**WELWYN HATFIELD COUNCIL – DEVELOPMENT CONTROL**  
**DELEGATED REPORT**

<b>APPLICATION No:</b>	S6/2008/0477/FP
------------------------	-----------------

**DESCRIPTION OF PROPOSAL:**

Great West Hyde House
 Garage 6/03/2/10
 1:100 RT 14/11/07

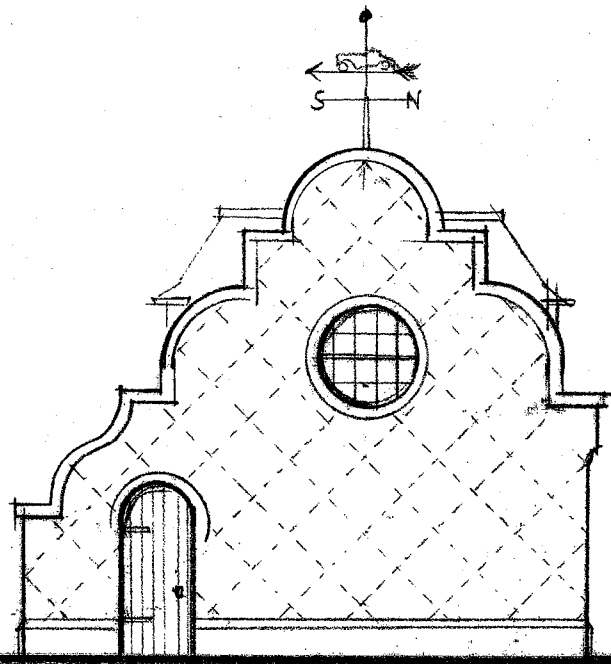
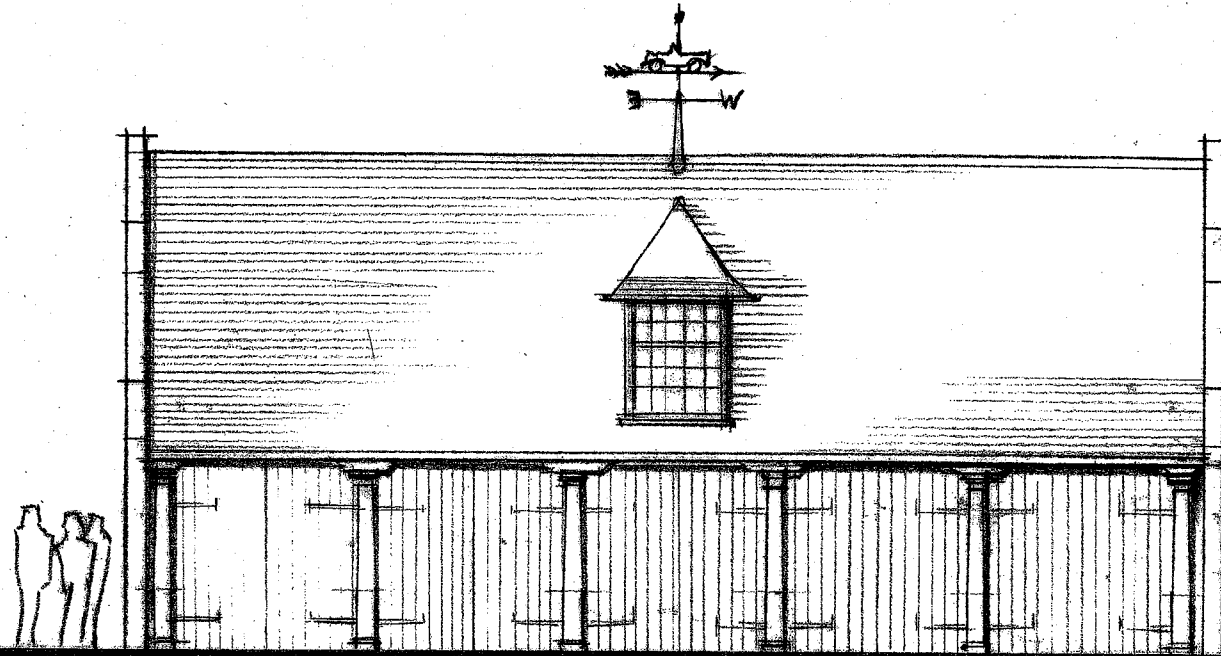
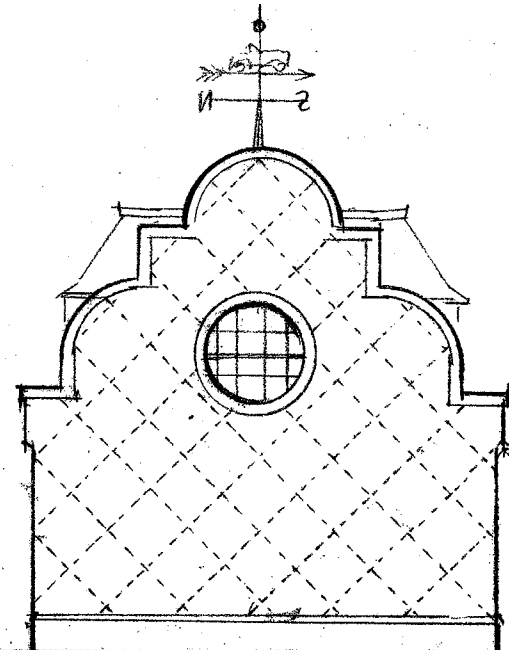
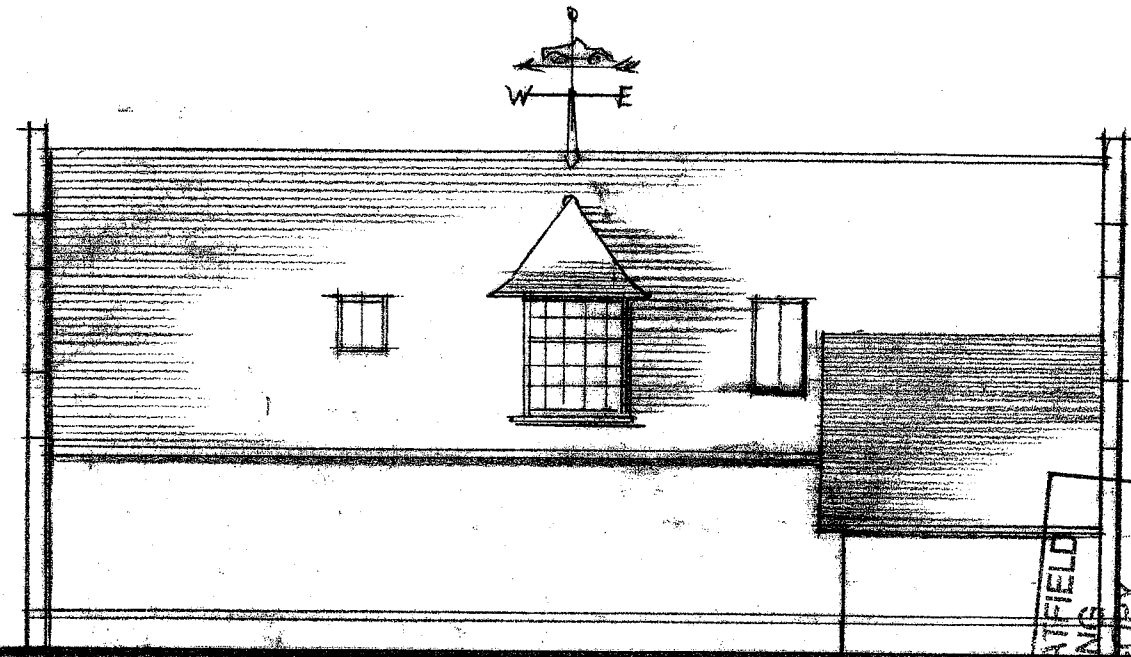
The proposed development would create a separate unit with residential accommodation above. Due to the design of the proposal it would have glazing at roof level, which would be noticeable from the surrounding area. The proposal would be viewed from Wilkins Green Lane and would be seen when approaching the main building. The proposed garage building would be within the same street scene and clearly be on the same plot as the main building. The proposal would have a maximum height of approximately 6.8m, which would mean that the building is viewed clearly above the adjacent boundary. Due to the proposed ornate design of the flank elevations and overall prominence of the building, it would have an adverse impact upon the setting of the main Listed Building. It has been acknowledged that the design has been based on a previous feature of the main building. However, this addition would not reflect the existing Listed Building and would not enhance its setting.

When considered cumulatively with the recently approved entrance gates and pillars the, the appearance of the proposal would be exacerbated. The proposed garage building would have an inappropriate design that would detract from the appearance of the Listed Building. The proposed building would also be excessive in terms of its mass, bulk and prominence. When considering with the proposed garages and proximity to the adjacent highway, it would have an adverse impact upon the character, appearance and setting of the Listed Building. The proposed development would therefore be contrary to PPG15.

The proposed garage building would be overly prominent and would not be in keeping with the existing character of area. Due to the proximity Wilkins Green Lane, this addition would appear out of place and not comply with the requirements of Policy D2 of the Welwyn Hatfield District Plan 2005.

The proposed garage building would be a large and bulky addition set away from the existing property. This addition would be prominent and spread development away from the main dwelling, which would have an adverse impact upon the open character of the Green Belt. The proposed garage building would appear two storey and overly prominent within the existing street scene. The proposed garage building would also incorporate a separate residential unit within the roofspace. This addition would be very independent from the main dwelling and is considered to be an inappropriate addition within the Green Belt.

The proposed detached garage would form a highly prominent structure within the immediate setting of the main house. The garage would detract from the appearance of the Listed Building and have a detrimental impact upon the existing character an appearance of the locality. There is insufficient evidence to justify such a significant change and harmful impact to their overall appearance. The proposal therefore does not comply with the requirements of Policy D2 of the Welwyn Hatfield District Plan 2005 and PPG15 (Planning and the Historic Environment).

Parking & Indicative Garden plan

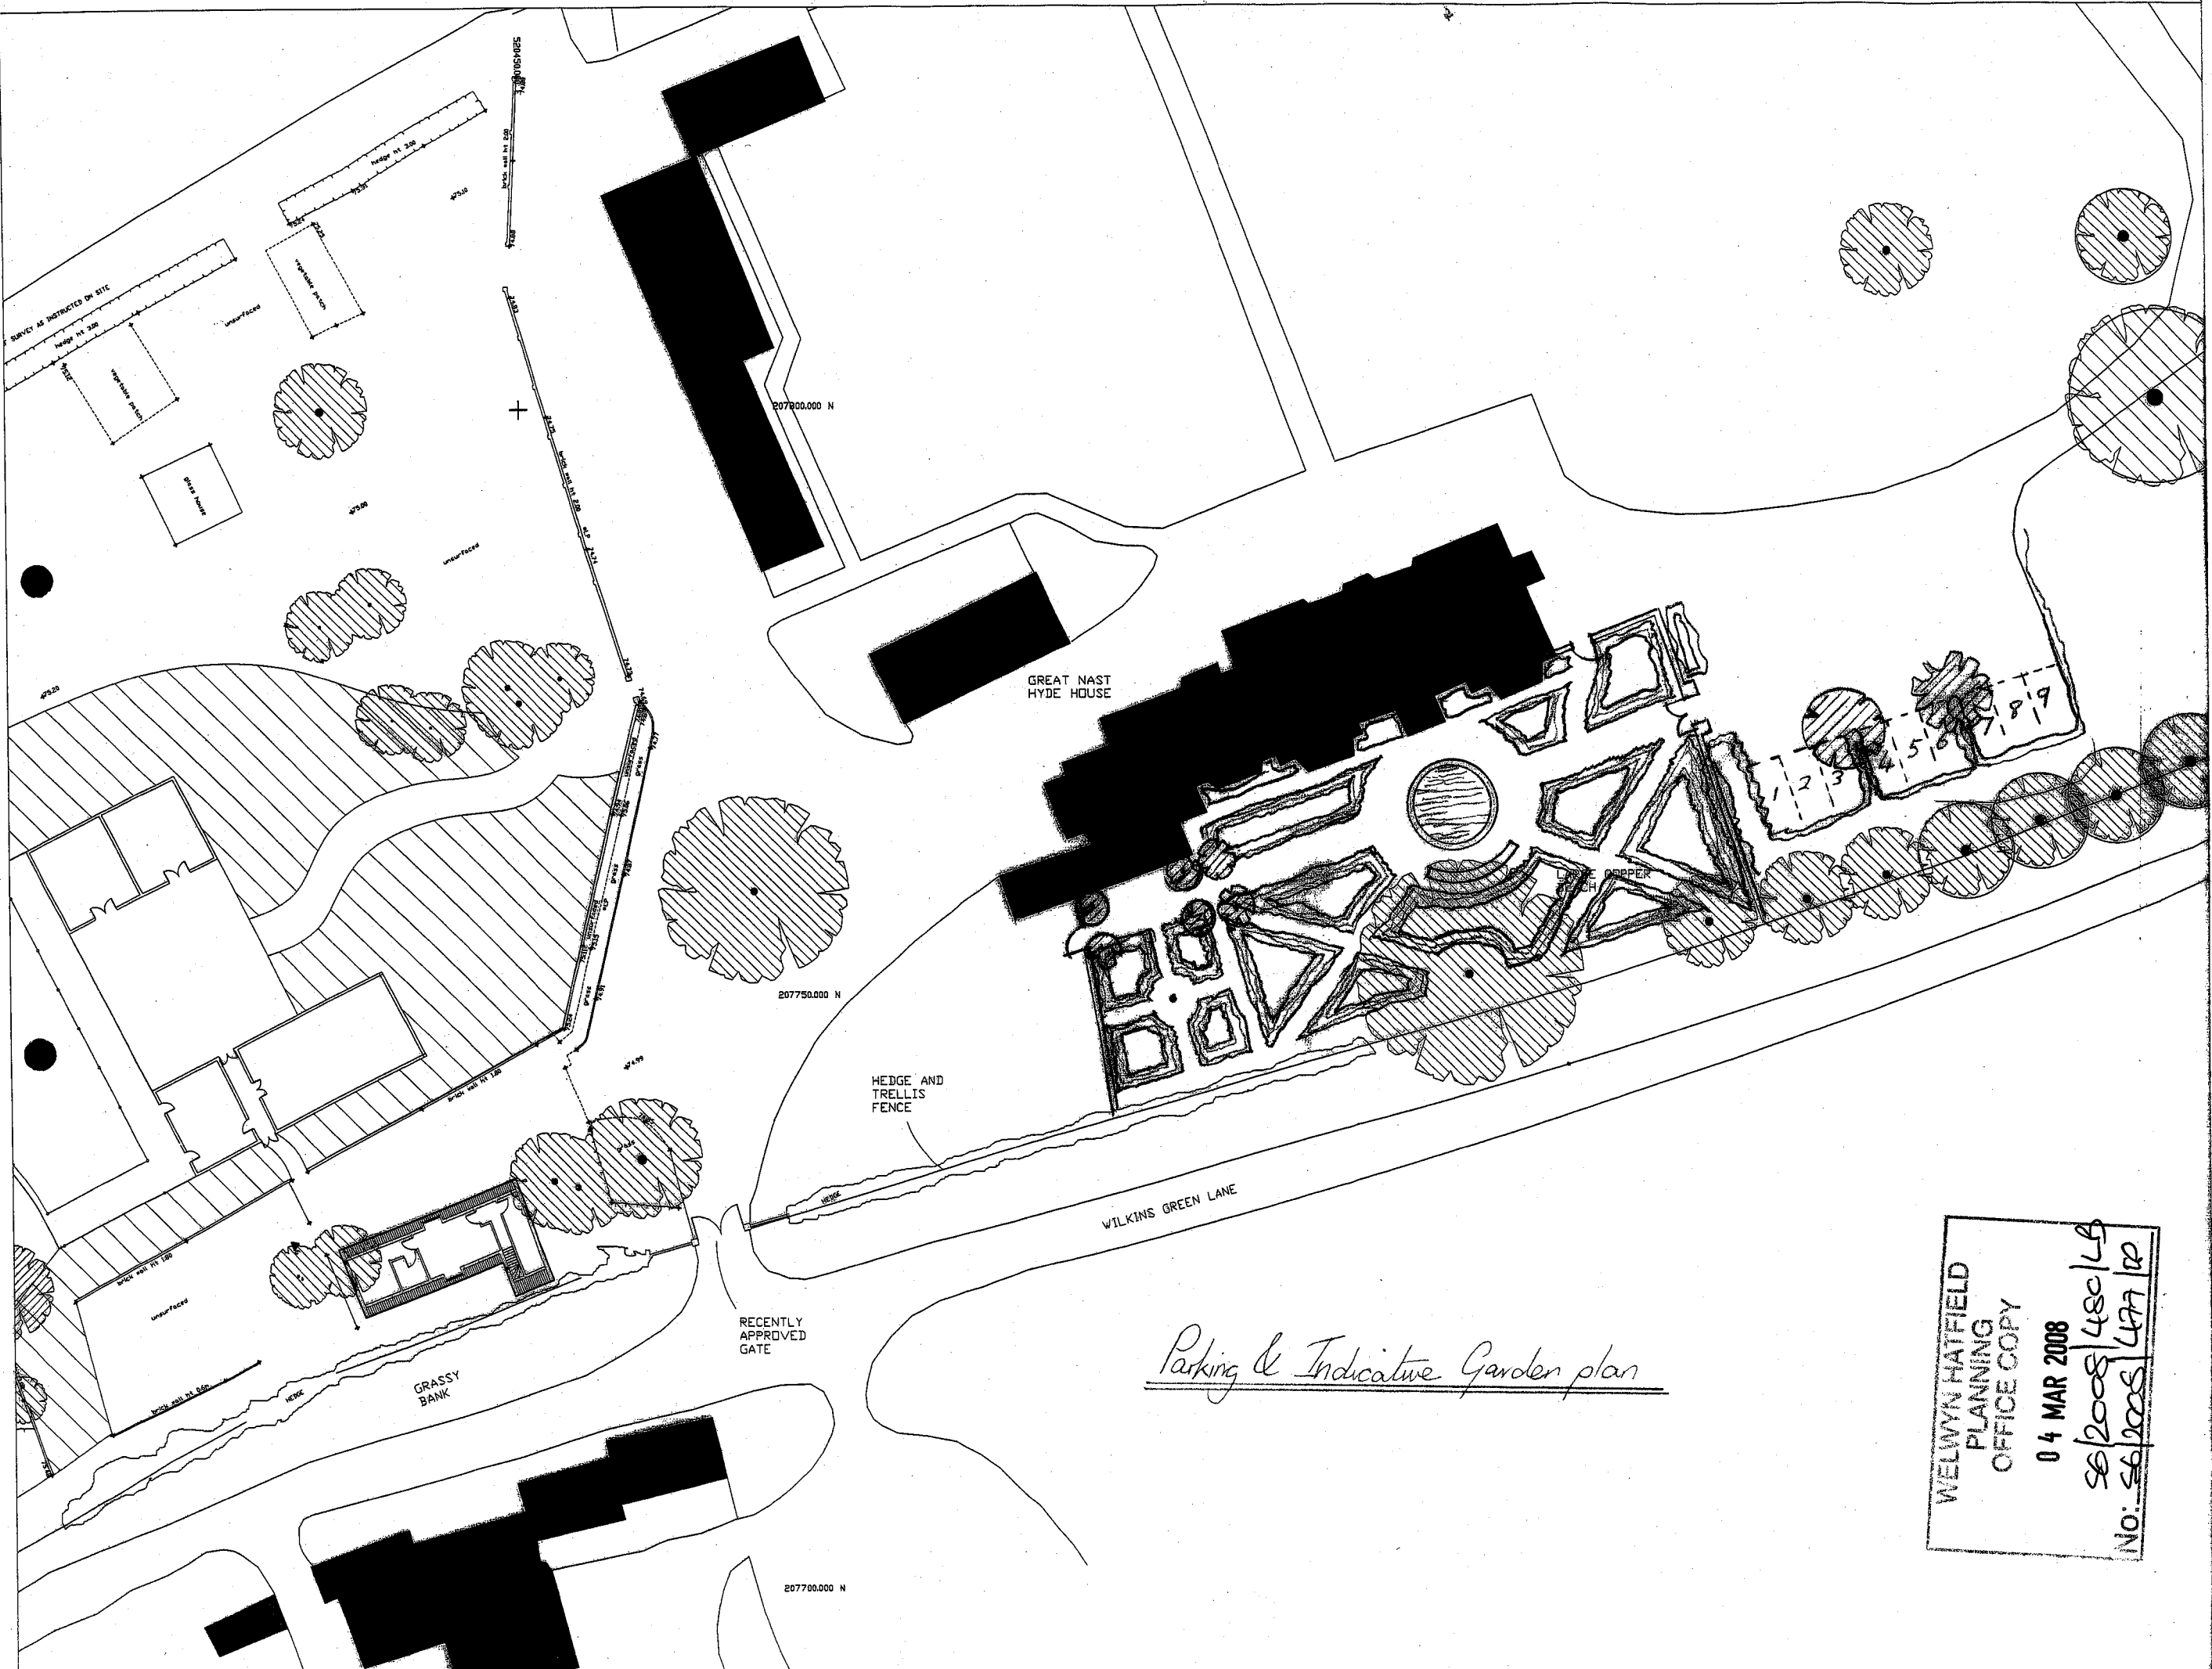
The proposed parking area would be sited beyond a screen of mature vegetation. The extension of the hardstanding to cover this area would not be viewed from the surrounding areas and would not have an adverse impact upon the character and appearance of the locality.

Elevation of New Foot Gates

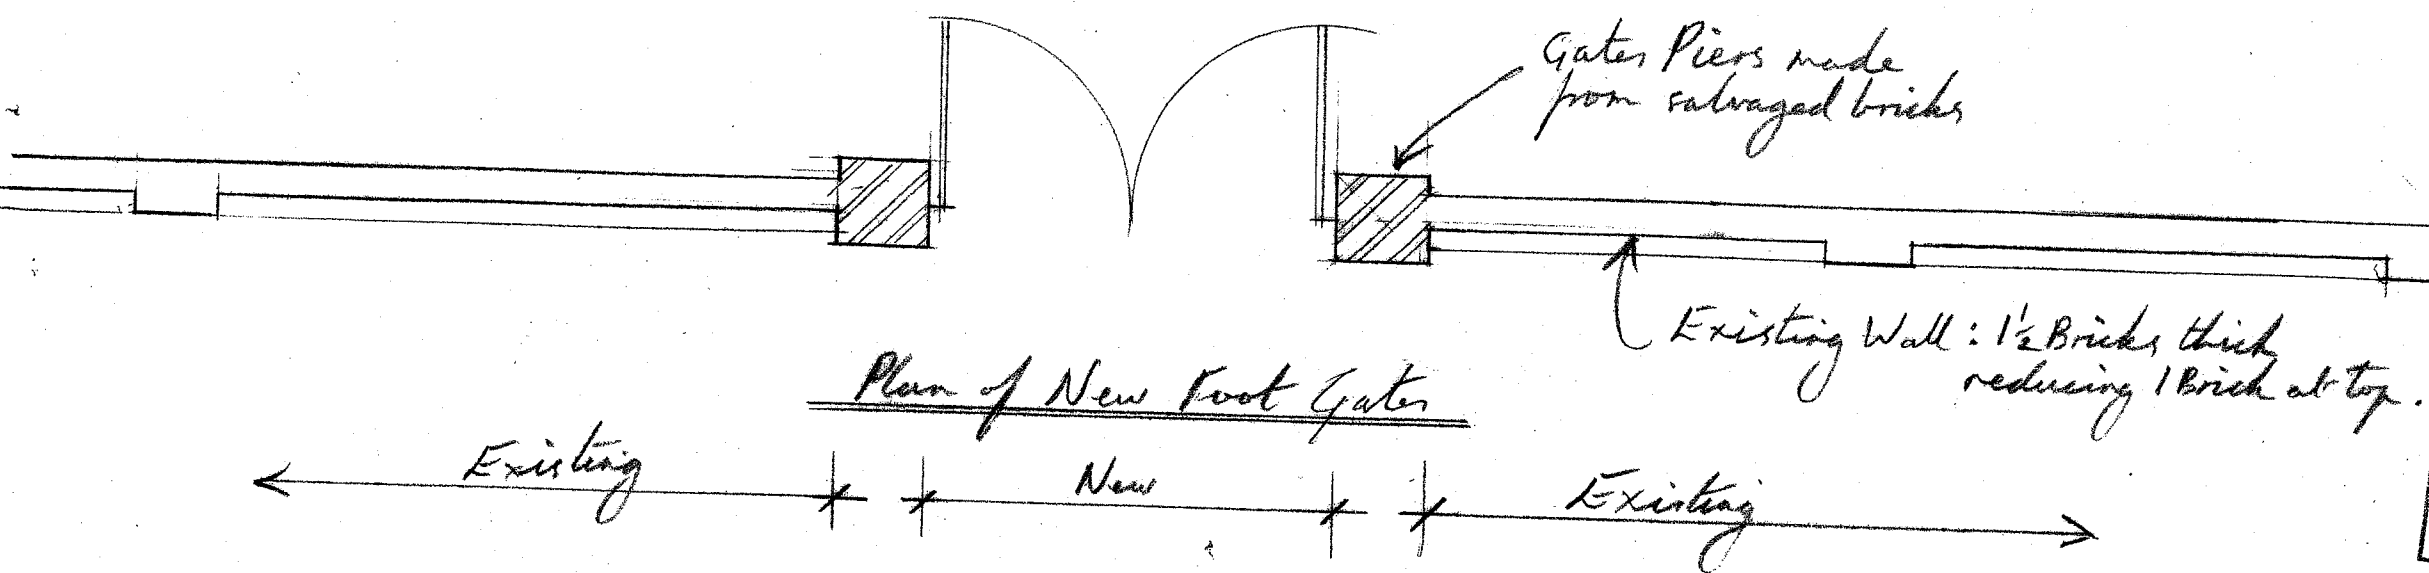
The proposed footgate would not have an adverse impact upon the appearance of the Listed Building. This addition would not have a significant height above the existing wall and would be adjacent to existing built development. The proposed design would be appropriate for the setting and would be in keeping with the recently approved entrance gates. The proposed footgate and the gates that were recently approved are intended to be convincing in terms of design, materials and scale. When compared to other historic properties the agent considers the proposed gates to be historically correct and convincing within the setting of the Listed Building. Due

to the large area of land surrounding the proposal and trees and vegetation within view, the proposed gates would not appear particularly prominent.
